**KIRKLEES METROPOLITAN COUNCIL
INVESTMENT & REGENERATION SERVICE**

**DELEGATED DECISION TO DETERMINE APPLICATIONS FOR
CONSENT, AGREEMENT OR APPROVAL REQUIRED BY CONDITION**

Reference No:	2024/44/90237/W
Site Address:	adjacent, Britannia Road, Golcar, Huddersfield, HD3 4QB
Description:	Discharge of conditions 3 (construction environmental management plan), 4 (public right of way), 5 (retaining walls), 6 (Phase II Report), 7 (Remediation Strategy), 9 (Remediation Validation Report) and 18 (Japanese Knotweed) of previous permission 2021/92062 for erection of 9 dwellings and associated works
Recommending Officer:	Nick Hirst

Application: 2024/90237

03 BOUNDARY TREATMENT - ADJACENT BUILDING SECTION SCALE 1:20

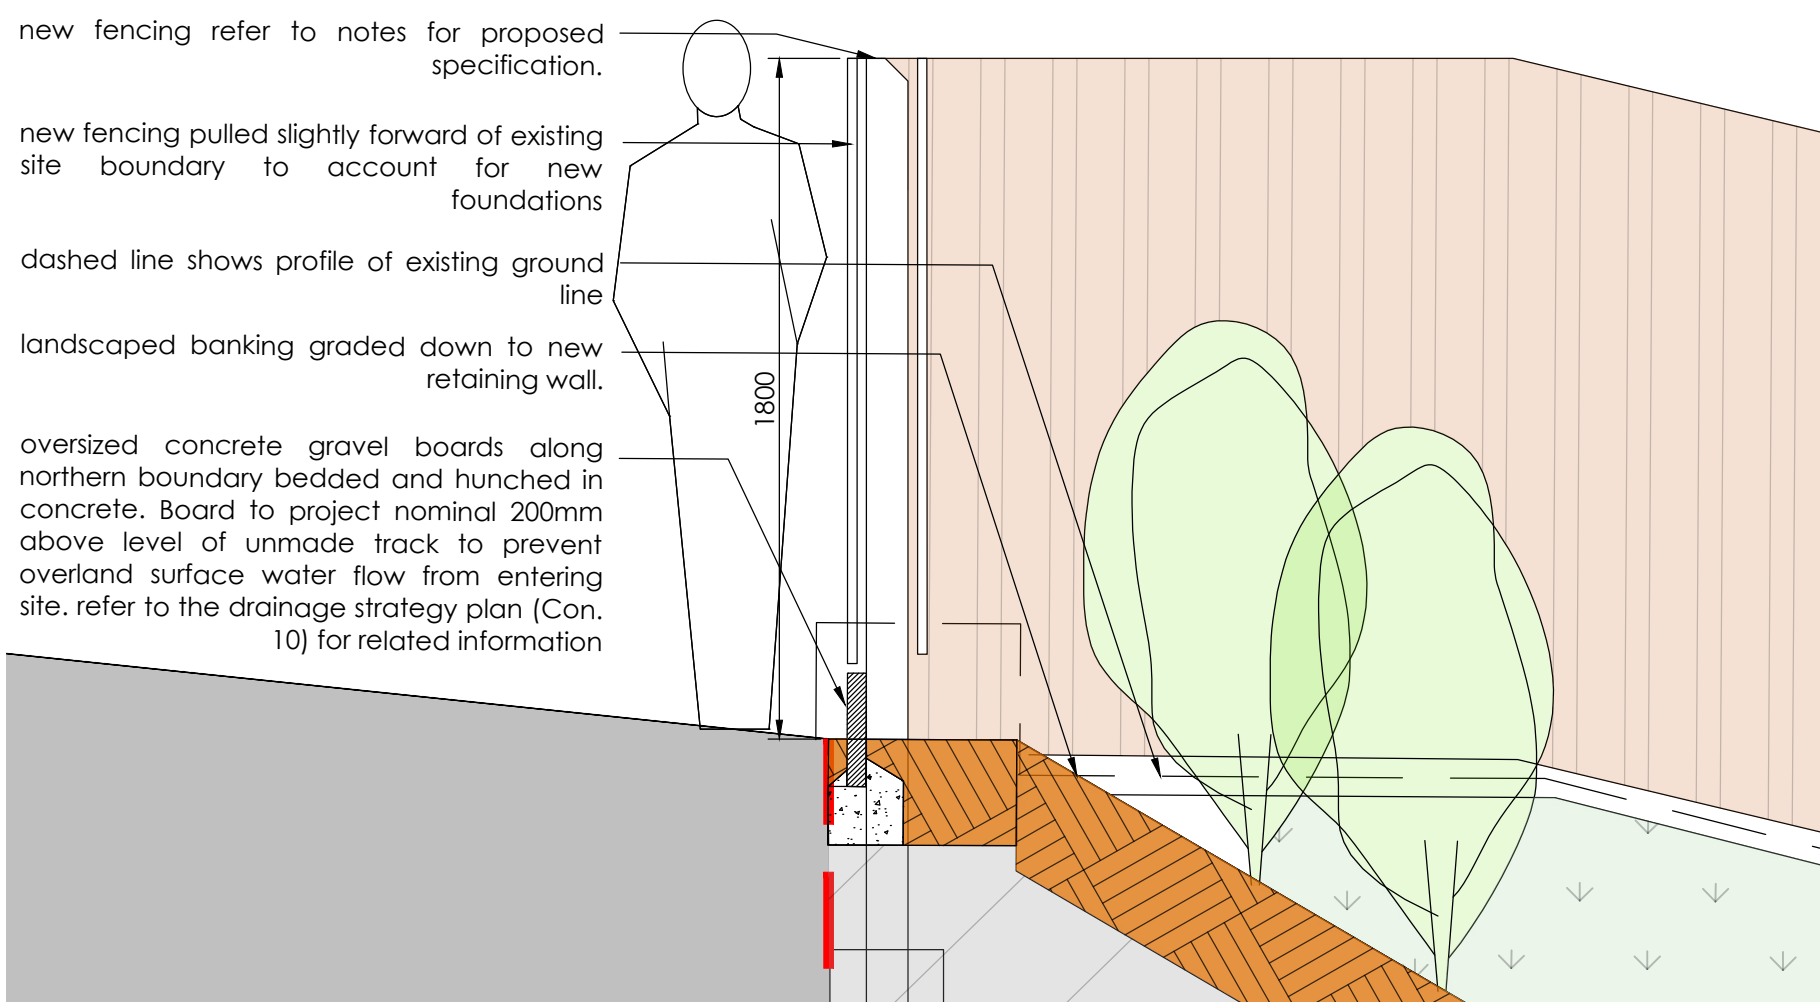
This condition requires technical and fully dimensioned sectional plans to detail the proposed engineering and retaining works, to allow officers to assess that the works would be undertaken safely and without prejudicing the stability of the highway (including PROWs). No such details have been provided and K.C. Highways (Structures) have raised an objection.

In addition to the missing details, the plans which have been submitted (including a block plan and non-dimensioned sections) indicate changes to the approved plans. This includes previous vertical retaining walls being changed to batters. It is beyond the scope of this DoC submission to amend the approved plans.

This condition requires technical and fully dimensioned sectional plans to detail the proposed engineering and retaining works, at or near the new and existing highway, to allow officers to assess that the works would be undertaken safely and without prejudicing the road network. No such adequate details have been provided.

Further to the above, the plans which have been provided indicate changes to the proposed design and method of retention / engineering works within the site from the approved plans. It is outside the scope of the Discharge of Condition process to make such amendments to the approved plans.
